Development Control
Ribble Valley Borough Council

Re: Planning Application 19/0132

Address: Parcel 4 Land to the west of Malt Kiln Brow Chipping PR3 2GP

Description: Reserved matters approval for the residential development of four new dwellings with associated infrastructure and landscaping.

Client	Mr S. Chicken		
Project	Parcel 4, Church Raik, Malt-Kiln Brow, Chipping		
Drawing Title	SITE LAYOUT AND LANDSCAPE CONTEXT PLAN		
Drawing No.	1624SCP/ChP4-SL1		
Revision	Checked		
D	Drawn	D.G.Lever	
	Scale	1:500@A3	Approved
	Drawn	1st Nov 2018	
E-mail:	darren.dgl@gmail.com		A3

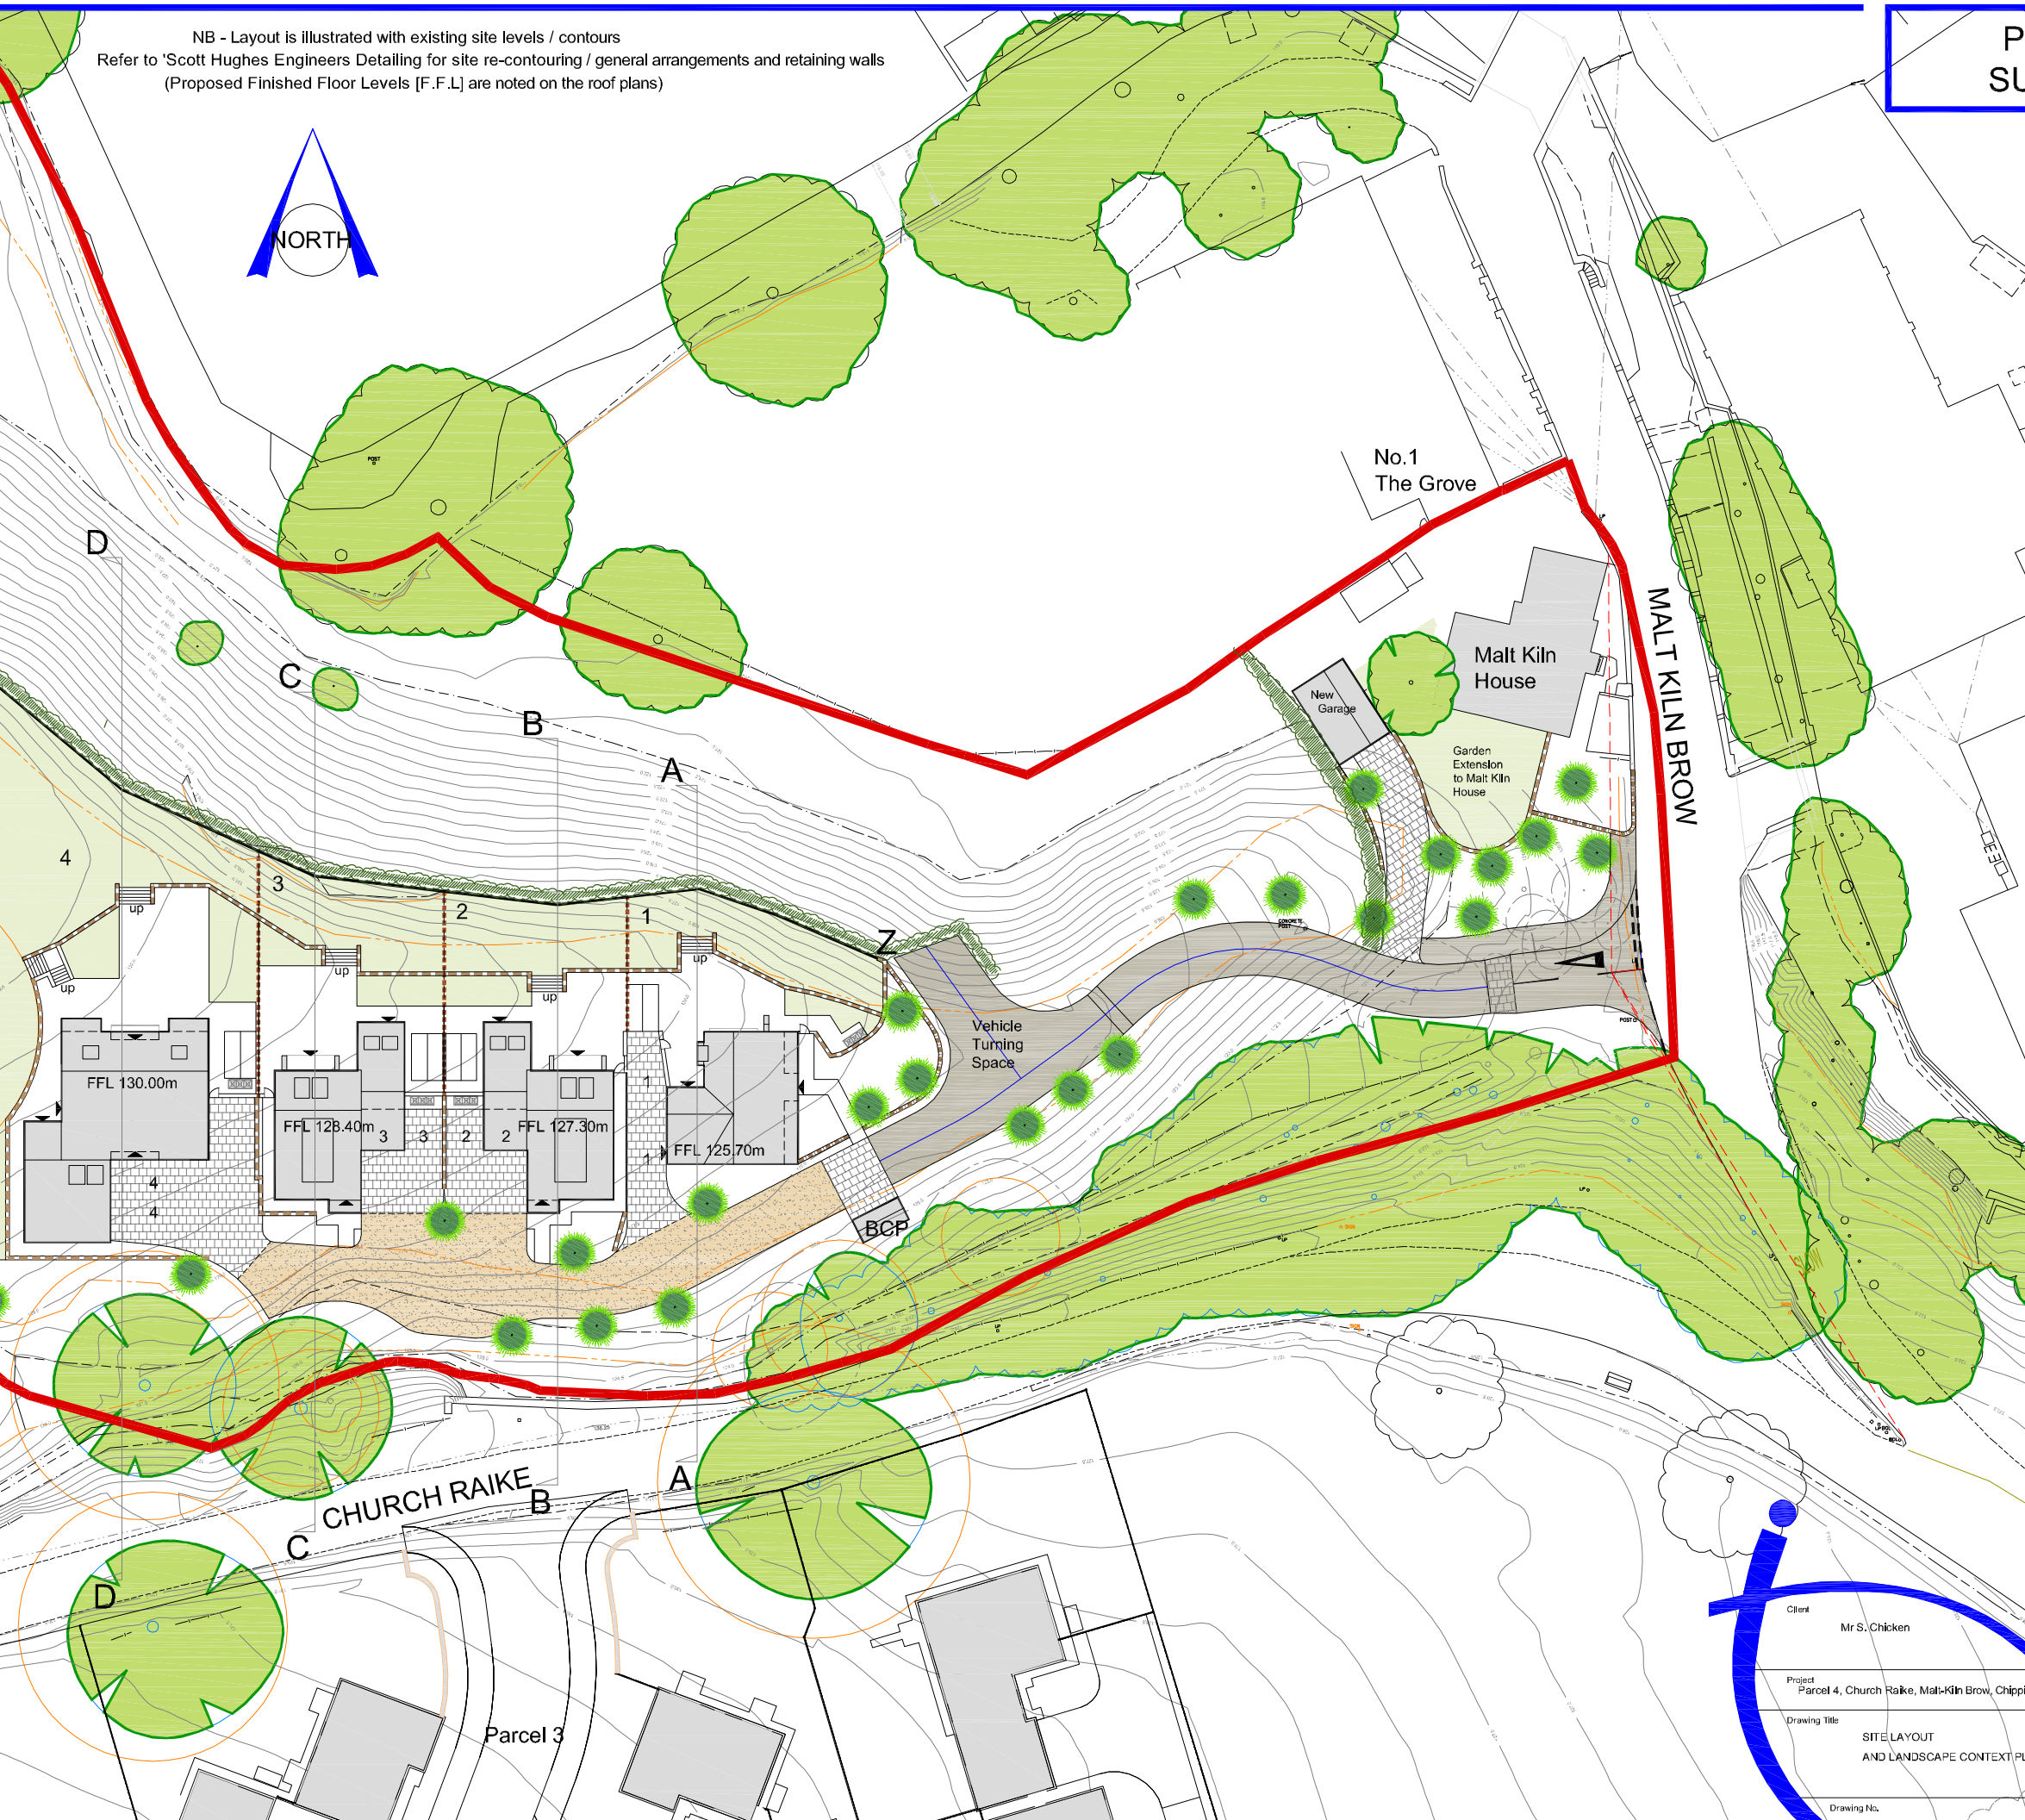
Generally, there are a number of issues regarding the lack of footway and/or service strip, the drainage of the site, the turning head and the location of the bin storage point with relation to the distance that the waste should be carried.

- It is expected that a footway should be provided, this could contain the service strip if this is suitable. The footway should be a minimum of 1.8m wide.
- The refuse collection point should be in a more central location.
- There is a concern over the sloping nature of turning head a cross section of this would be required to show the gradient. In order to ensure that the turning head is useable we would not expect a gradient of more than 1:40.
- There are no drainage details provided regarding the site.
- There are some notes attached which should provide guidance regarding the siting of the turning head and the bin collection point.

It is also noted that the planning submission makes reference to a Highways Access Drawing No. 3431-SDH-00-ZZ-SK-C-0005 Rev P2, this drawing has not been provided as part of the application and should not be taken as having been approved.

4. A turning head is required to allow refuse vehicle and emergency vehicles to turn within the site for the following reasons: -
 - The maximum distance a refuse vehicle should reverse is 12m, from Manual for streets and BS5930: 2005.
 - Fire and rescue Services Section should not have to reverse more than 20m from the end of an access road. From Manual for streets and diagram 24 of Approved Document B (Fire Safety).

5. Additional considerations when locating the Bin Collection Point are:-
 - 25m is the maximum distance a two wheeled refuse container is to be transported to the refuse wagon. From Manual for streets and BS5930: 2005.
 - 10m is the recommended distance a four wheeled refuse container is to be transported to the refuse wagon. From Manual for streets and BS5930: 2005.
 - A resident should not be required to carry the waste more than 30m to the refuse storage point. From Manual for streets and BS5930: 2005.
